I refer to the above planning application for Long Acre, Little Heath Road. I am the adjacent owner, at Pine Trees, since November 2019.

Having examined the application, the proposal for the north elevation of Long Acre would appear to have a considerable effect on my property because it is very close to the boundary and the increase in height prompts a concern about possible overlooking as well as concern about the new silhouette and loss of daylight and sunlight.

Proposed Extensions and Alterations
at
Long Acre, Little Heath Road, Fontwell
for
Mr and Mrs G Devenish
Drawing PL13 August 2020 Scale 1:500 @ A3
Planning Drawing - Block Plan

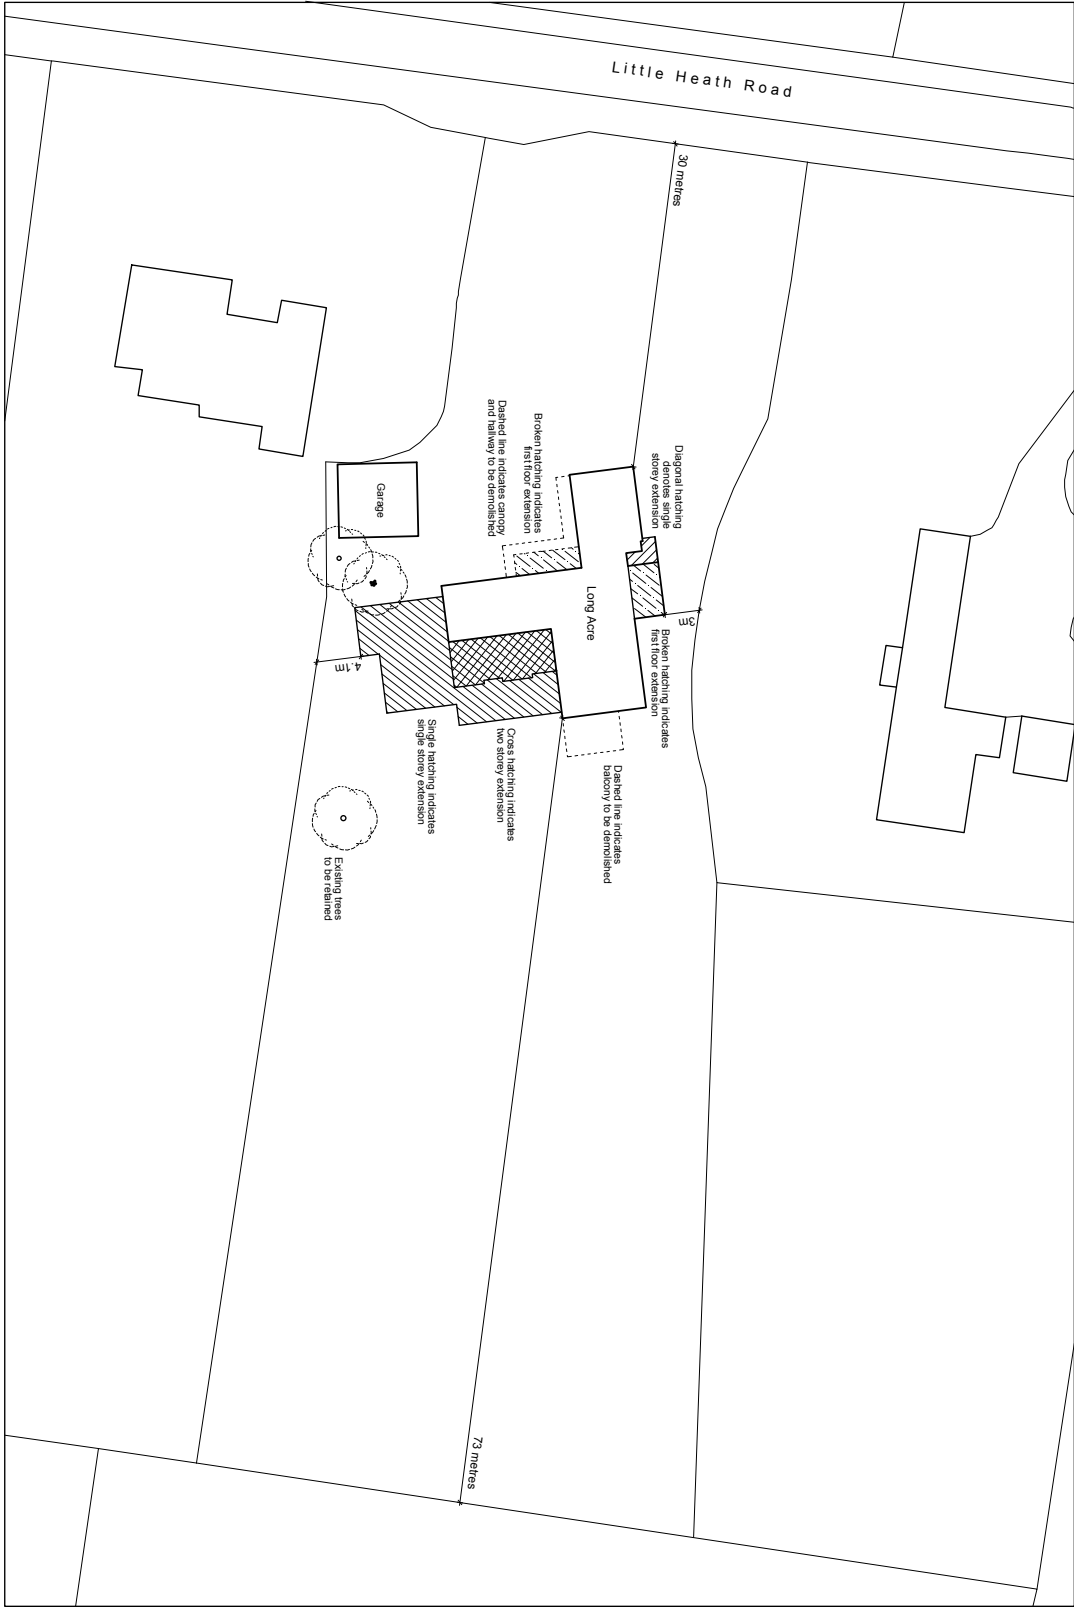
Importantly, the site plan appears to be based on an old OS map which does not show our garden room, which means that our house is considerably closer to the boundary than it appears on the plan. The proposal for the north wall of Long Acre appears to be inaccurate in that it is already considerably closer to the boundary than is indicated on the plans and the new building will be substantially closer to our boundary than the 3 metres indicated. This area between our two houses is important to us; as well as our south facing garden room we have an adjacent sitting area facing south. The current prospect looks at a setback brick wall and chimney; its proposed replacement by a monolithic 2 storey wall with render is a disappointment and will spoil this important view. This is not acceptable.
